RFI

RFI #: 61  
Date: 2/22/2012  
Job: EB-02 Keller Springs Lofts  
Phone: 877-777-5115

Subject: Fire Extinguisher Cabinets Locations

Drawing: 3.1A, 3.2A, 3.3A, 3.4A, 3.4F  
Cost Impact: None

SHEET NUMBER
3.2A
BLDG PLAN 'A'

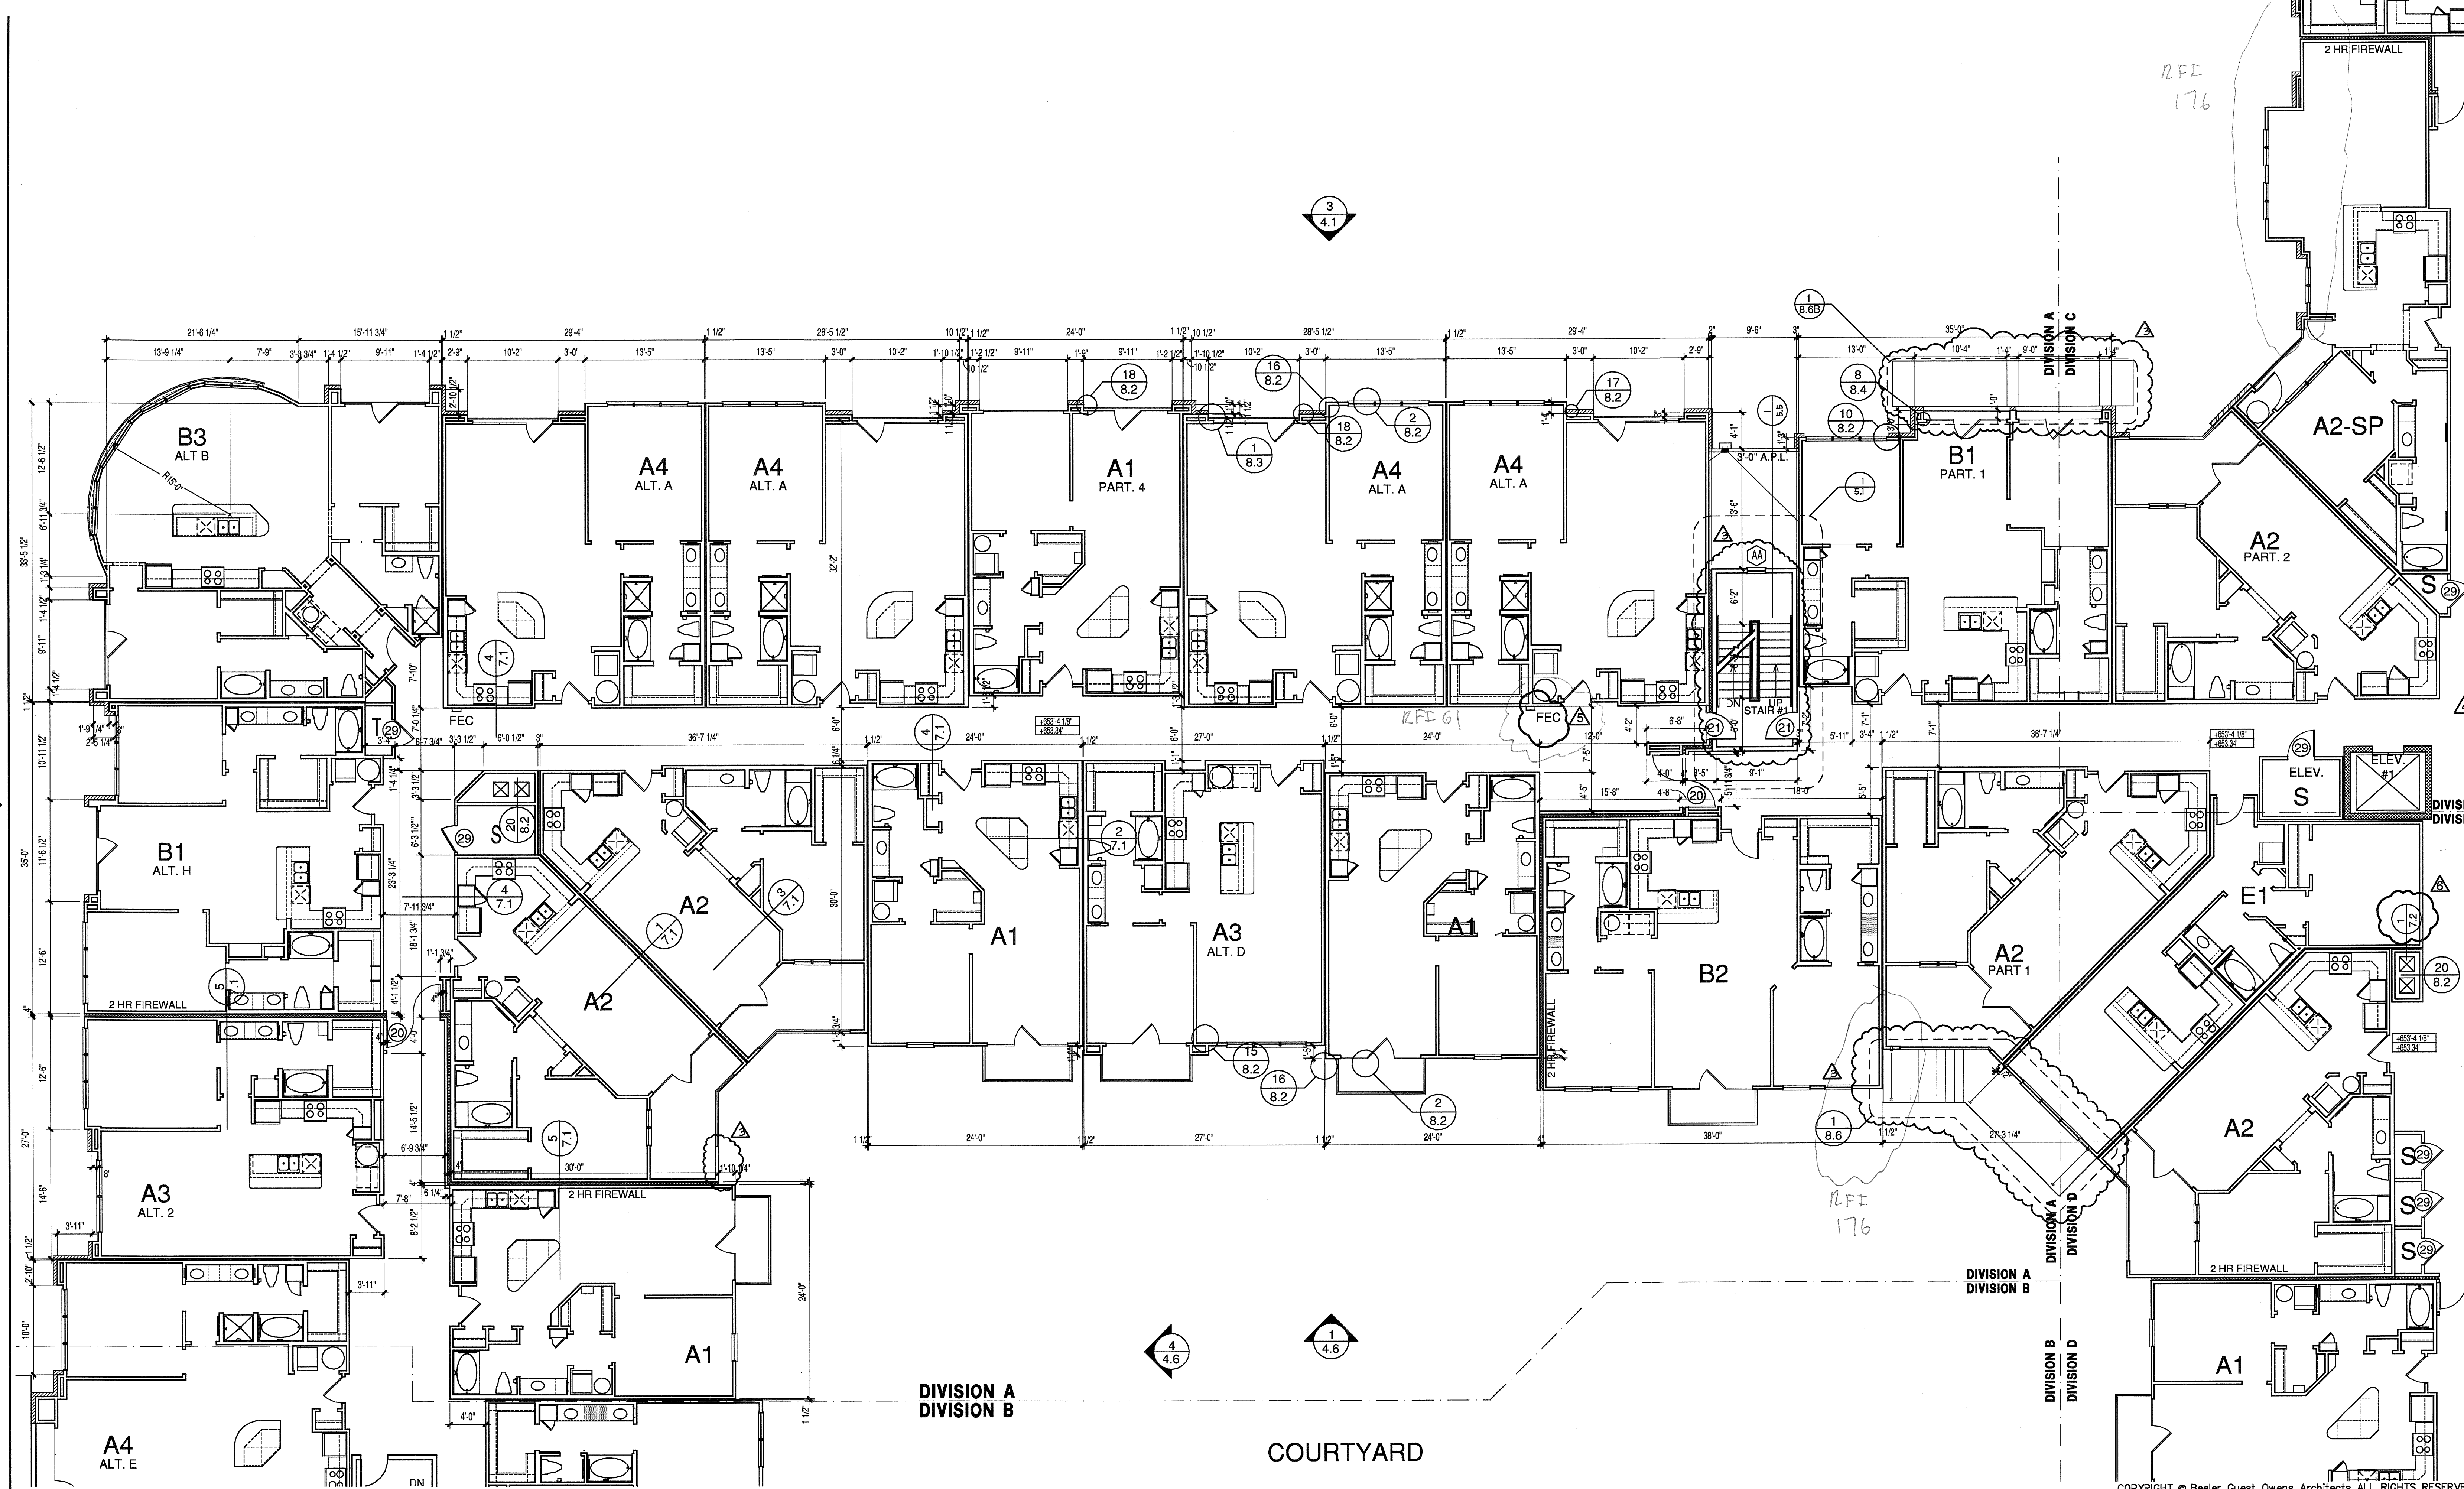
| 1) There are some inconsistency's with plans for FEC locations in corridors.<br>3.1A shows 2 FEC<br>3.2A shows 1 FEC<br>3.3A shows 1 FEC<br>3.4A shows 2 FEC<br>Do you want 2nd FEC added for 2nd & 3rd floors?         |                                 |

| <b>Response:</b>              | 1- Yes.<br>2- Yes. I've checked all locations and the one's you mentioned are the only problem locations. I adjusted 2 other FEC locations by moving them a foot or so now all FECs line up in the same spot from floor to floor (except for the Club and Garage areas).<br>3- I've placed the 2 FECs you mentioned in sheet 9.1<br>4- Yes, we need them in the parking garage. I've updated the sheets to reflect this. Double check with your local Fire Marshall, but I'm confident that a surface mounting will be fine. |

| SHEET NUMBER | 3.4F |

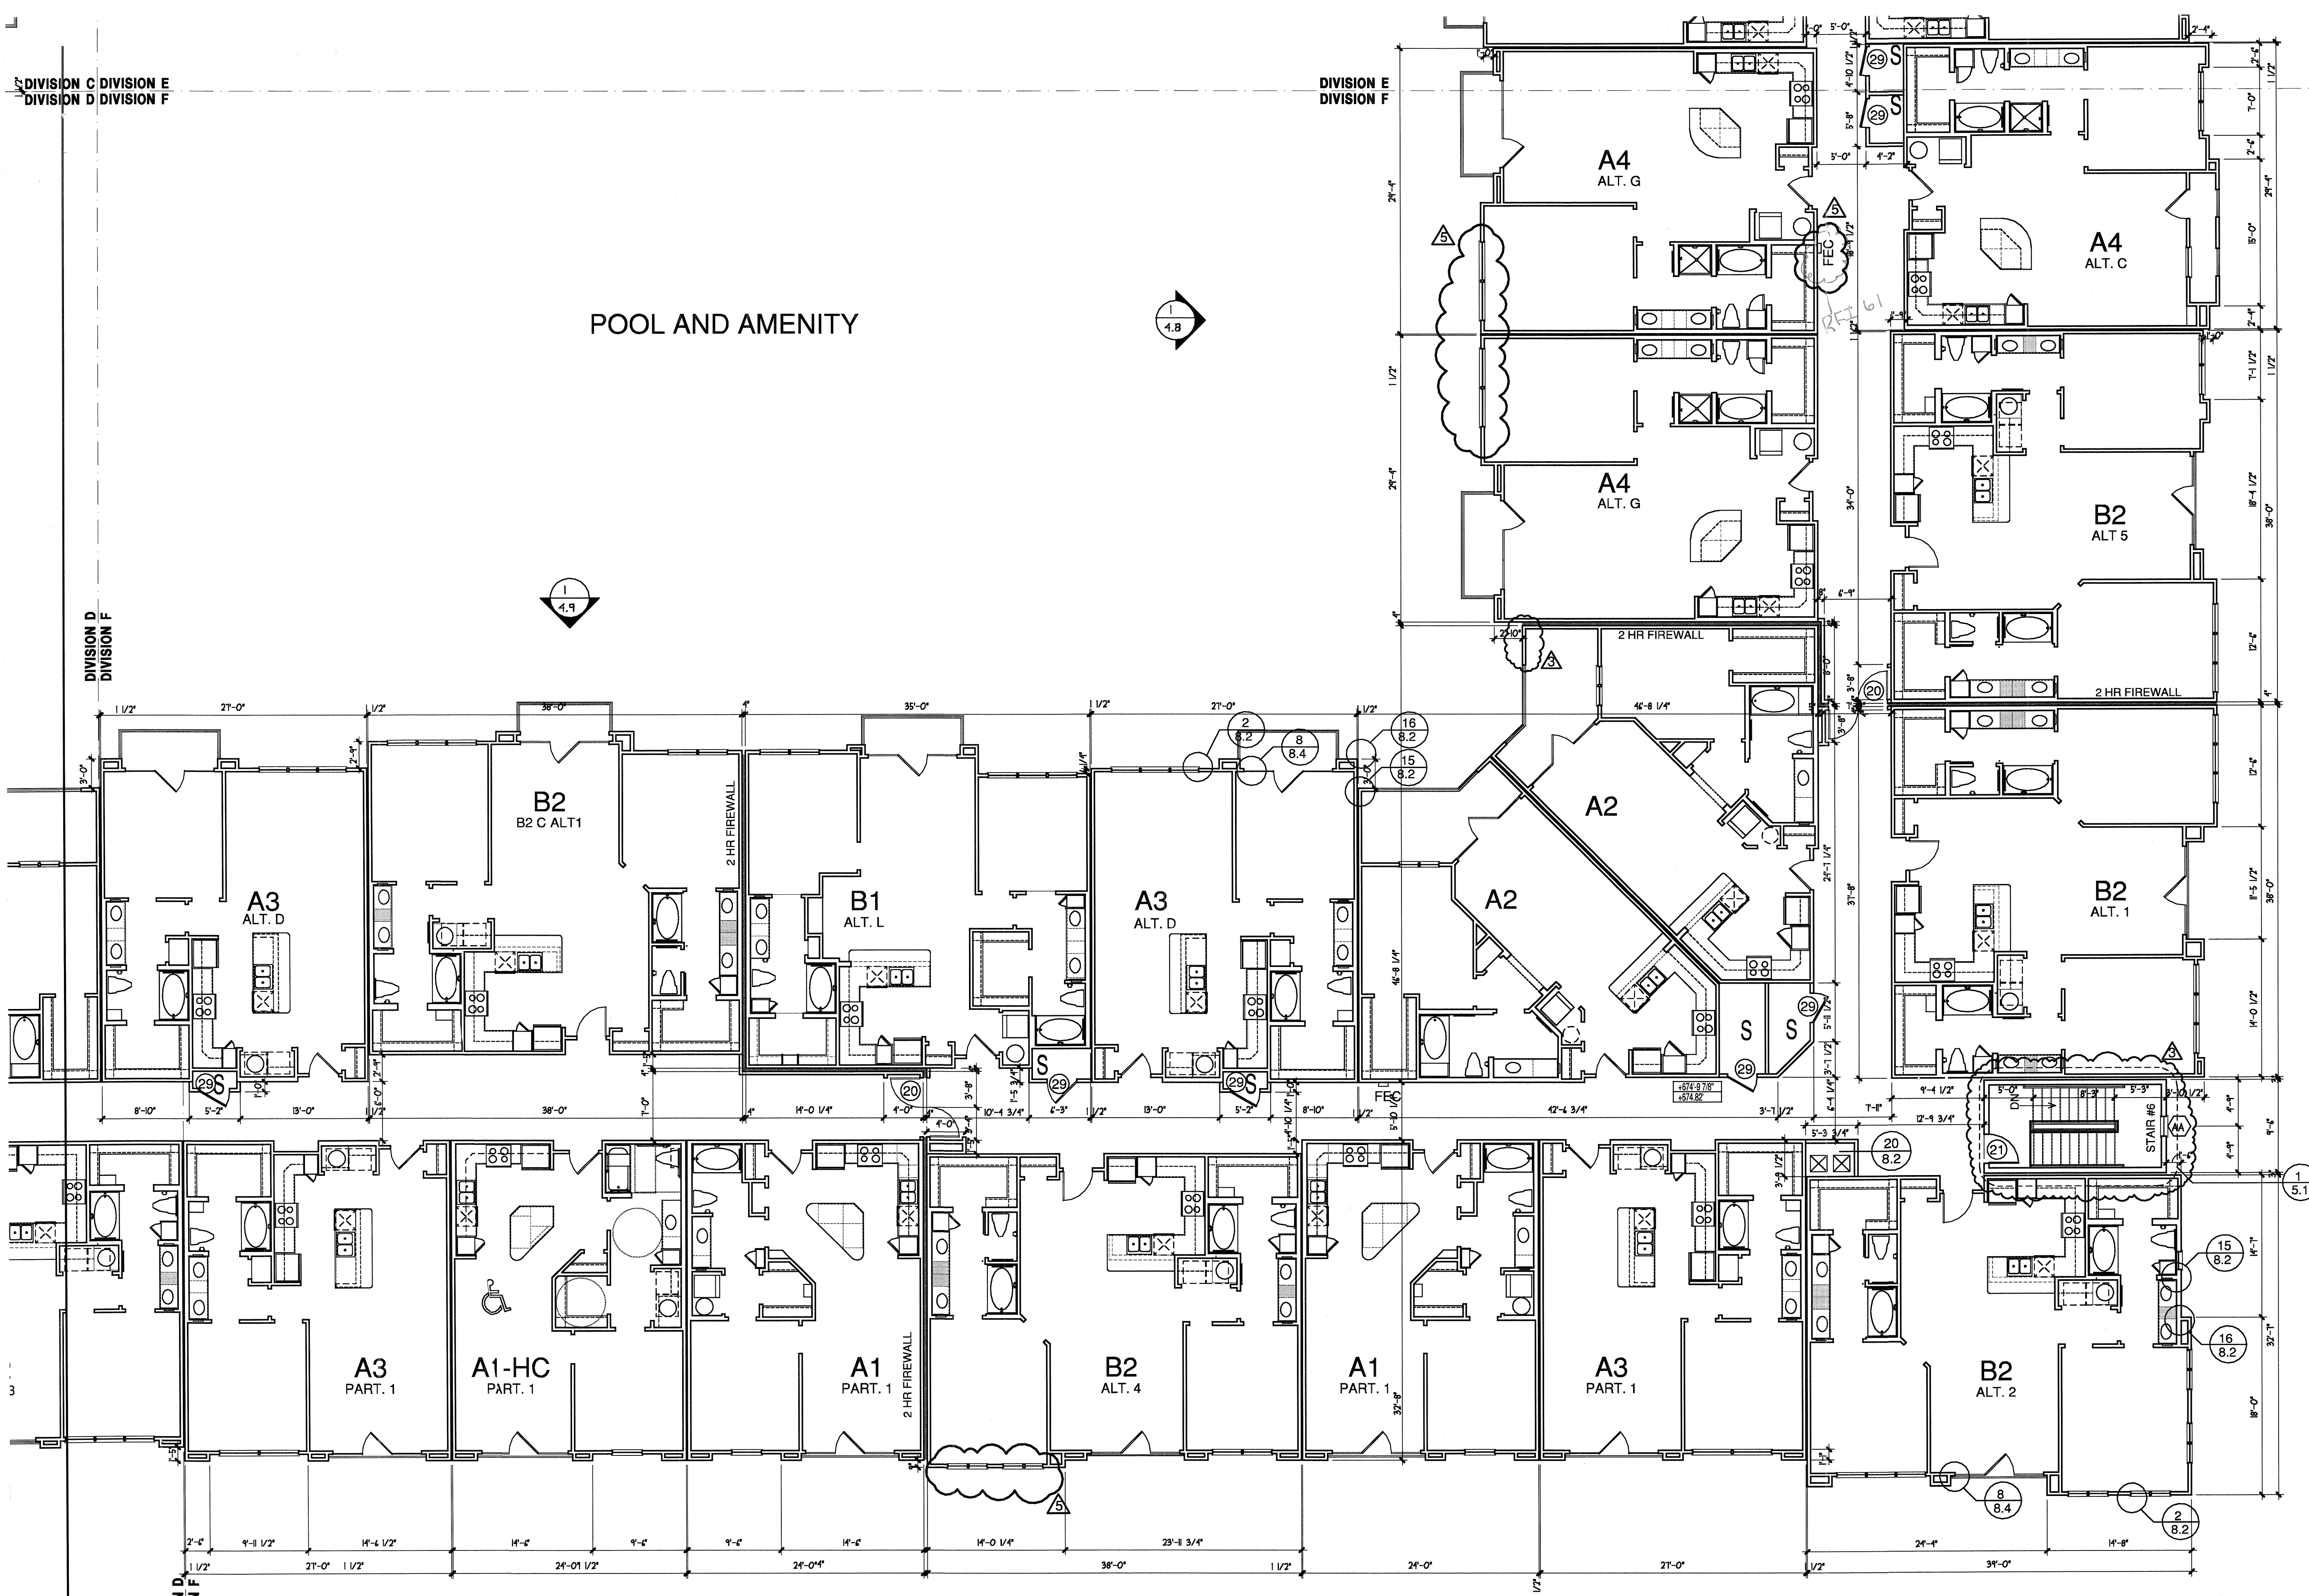
| 2) On sheet 3.4F - FEC mark is missing on A4 All G wall.<br>The FEC is shown on 1st, 2nd and 3rd floors, does the FEC need to be included at 4th floor?<br>Please verify all sections for coordination and consistency. |                                 |
